Our reference: R/2019/26/E

Your reference: SSD 10405 MOD 2

Subject: Request for Advice - Atlassian Office and Hotel Development (SSD 10405 MOD 2)

1.1 FIGURE 1 - PROPOSED BASEMENT LEVEL 2 PLAN (CONTINUED)

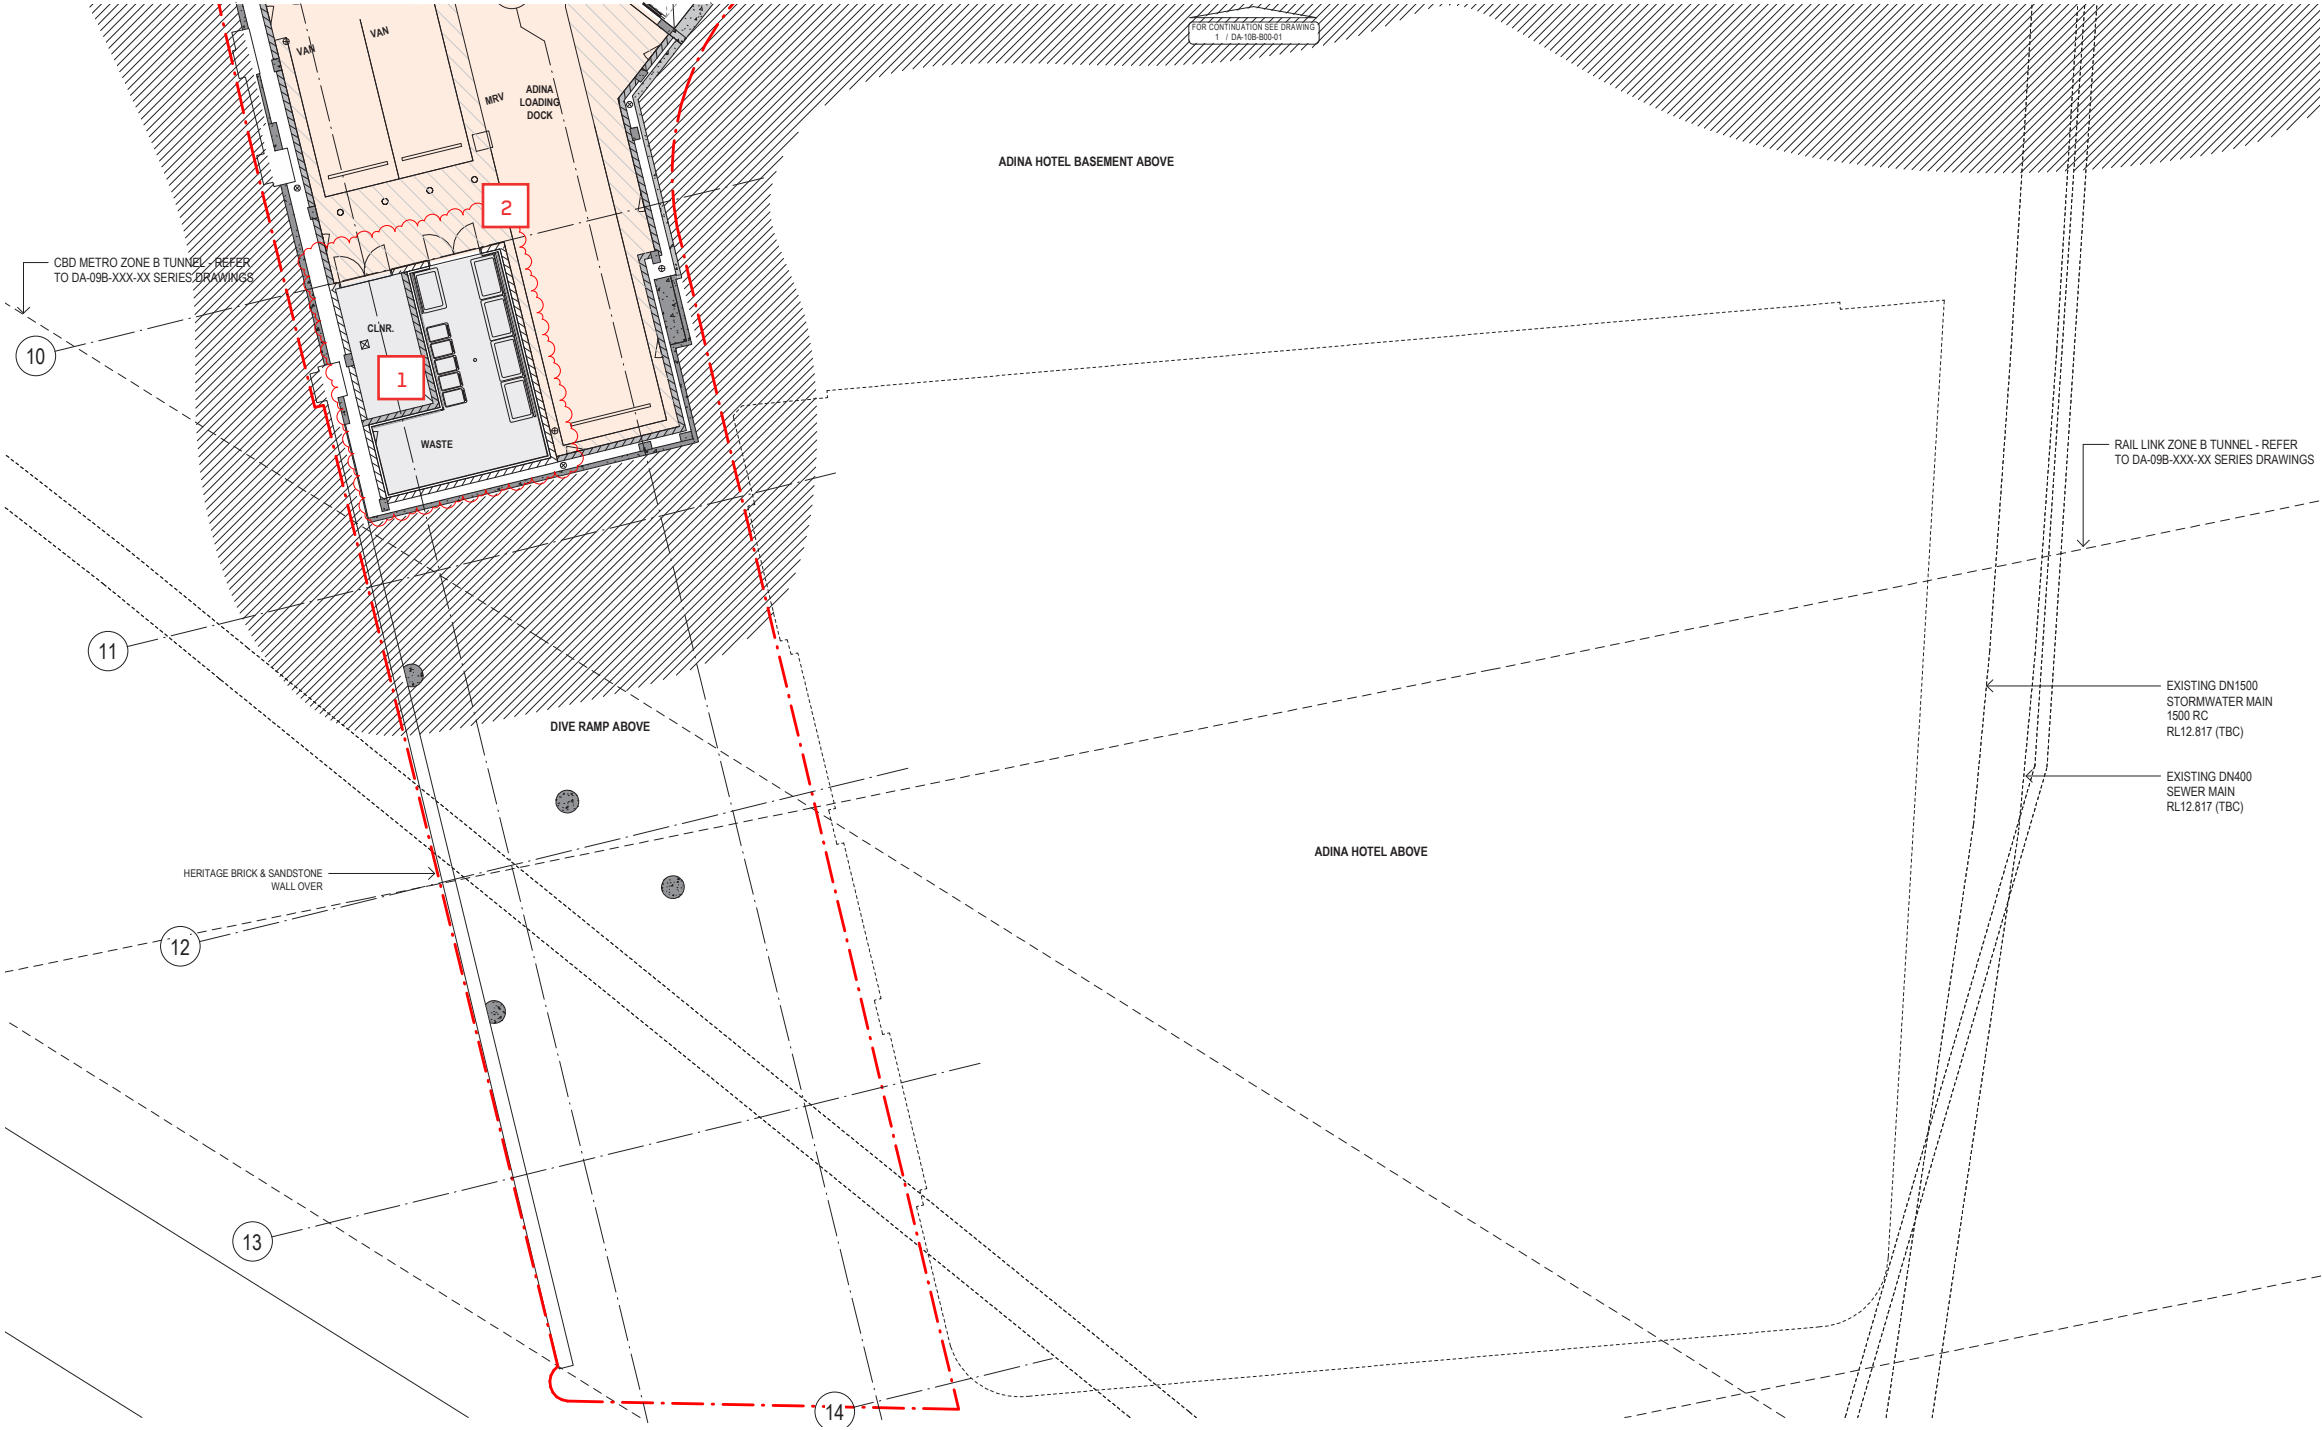
The internal reconfiguration within the basement levels includes a reduction to the Adina loading area in front of the waste room at Basement Level 2. It is unclear how waste will be serviced in this area. Sweb paths must be provided that demonstrate there is adequate space for a driver to enter and exit the vehicle and move the bins to the rear of the vehicle. It should also be noted that no bulky waste storage areas have been provided for the development. These should be provided in accordance with the City's Guidelines for Waste Management in New Developments 2018.

It appears that a waste truck will need to back into the collection point for rear lift collection. A roller door should be considered along the wall where the truck backs into its loading dock to reduce bin movement and improve bin access to the rear of the vehicle.
